DOC19/326707-1  
SSD 8795

**OEH review of Environmental Impact Statement, Karuah South Quarry, SSD 8795**

OEH has reviewed the Environmental Impact Statement, including relevant appendices, annexures, attachments and parts of the document titled '*Environmental Impact Statement for the Karuah South Quarry State Significant Development 17\_8795*' (prepared by R.W. Corkery & Co. Pty. Limited and dated May 2019) in relation to impacts on biodiversity, Aboriginal cultural heritage and flooding.

Figure 7 Survey Effort for Candidate Threatened Flora Species

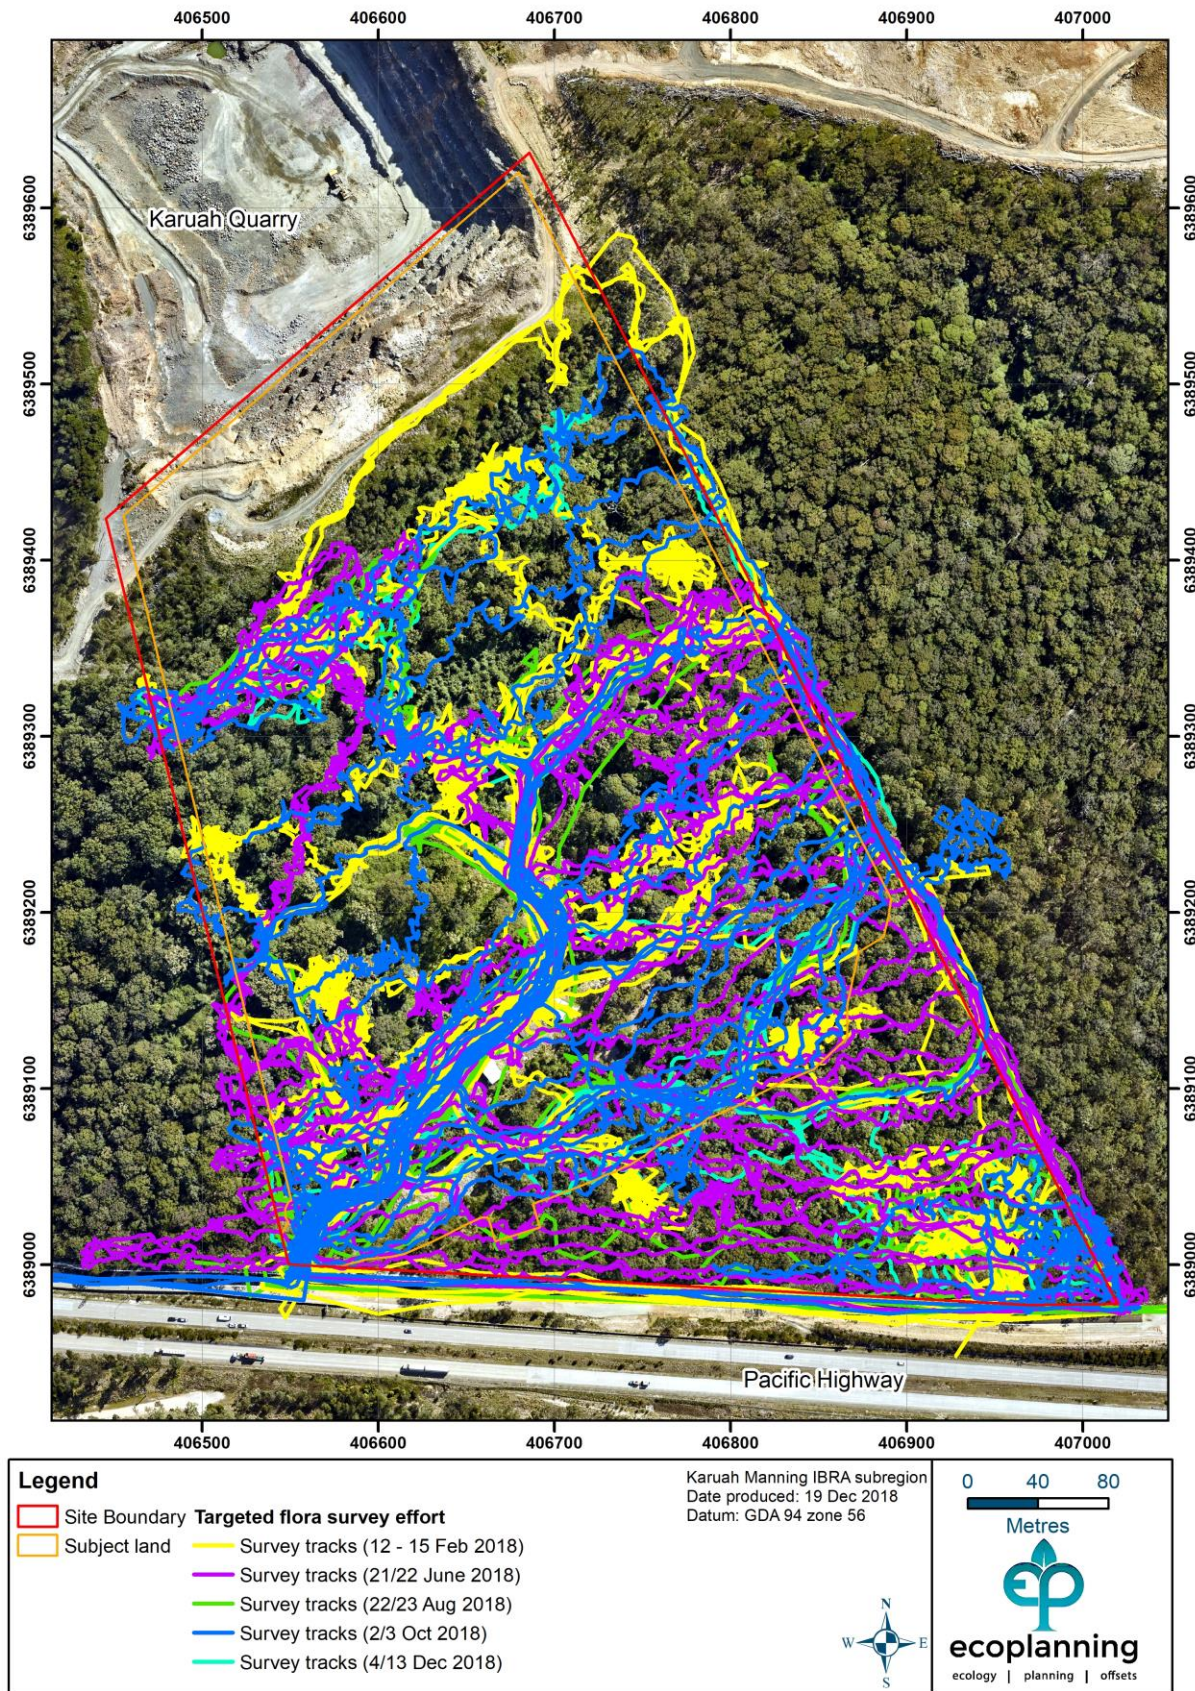
The Biodiversity Development Assessment Report (BDAR) Table 8 shows nominated survey months for threatened flora species (OEH, 2018) against months when flora surveys were undertaken for the BDAR. Some flora species identified in the BDAR with potential to occur are not shown in Table 8, including *Angophora inopina*, *Corybas dowlingii*, *Diuris praecox* and *Melaleuca groveana*. Table 8 of the BDAR should include these species, nominated survey months (OEH, 2018) and months when the flora surveys were undertaken for the BDAR to demonstrate these species have been adequately surveyed.

OEH recommends survey period for all threatened flora species is reported.

Figure 7 Landforms Surveyed

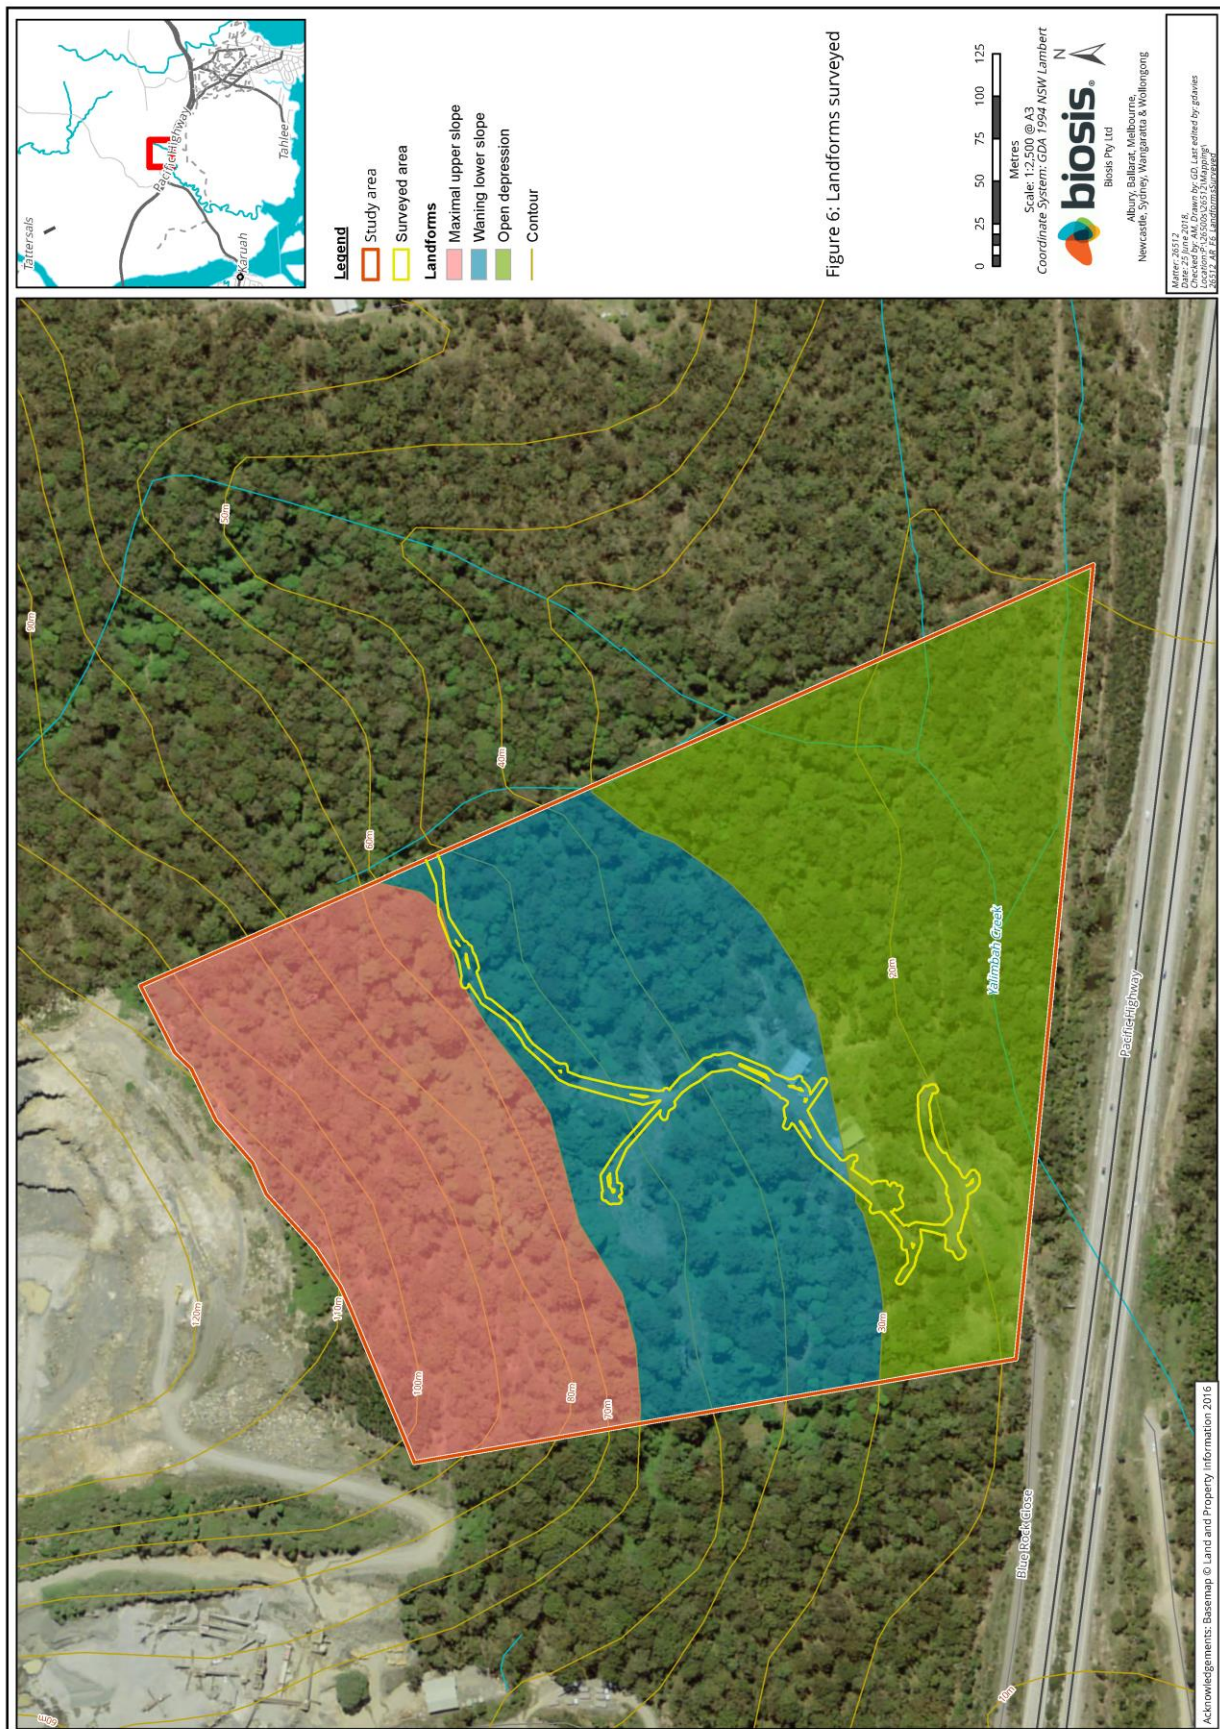
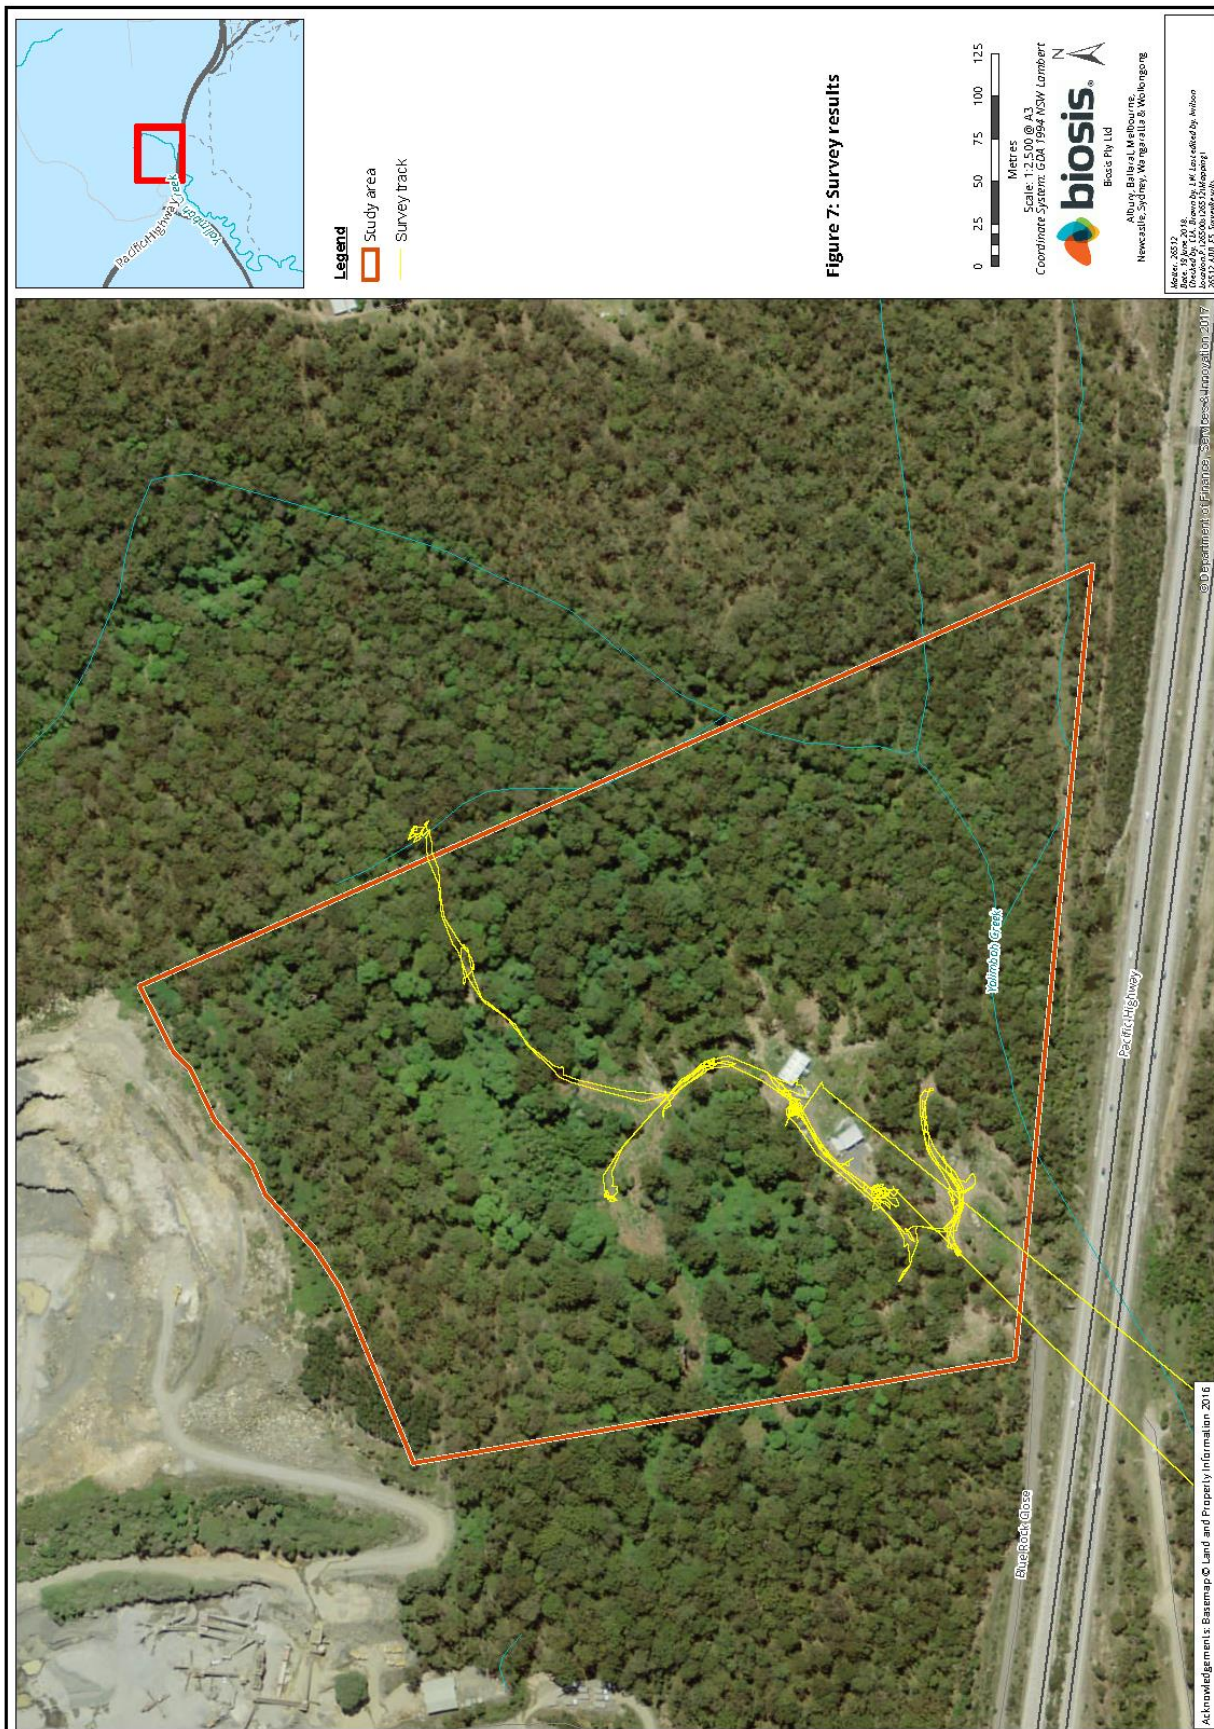
The Archaeological survey methodology in Section 5.2 of the Archaeological Report states that “the survey effort targeted all landforms within the Study Area”. Figure 7 and Figure 8 of the report shows that survey coverage was low and focused on cleared areas and tracks to the north west and upslope of the creek line. No survey was undertaken along the flatter, lower slopes flanking the creek line characterised by open forest.

Survey coverage was not adequate and excluded areas where Aboriginal sites were more likely to occur along creek banks and areas that would have had higher potential for accessible natural resources. OEH recommends that additional survey be undertaken in the southern portion of the project area. Additional consultation with the registered Aboriginal parties should be undertaken to provide them with the opportunity to participate in the survey.

OEH recommends that archaeological survey be undertaken in the southern portion of the project area with opportunity provided to the registered Aboriginal groups to participate in the survey.
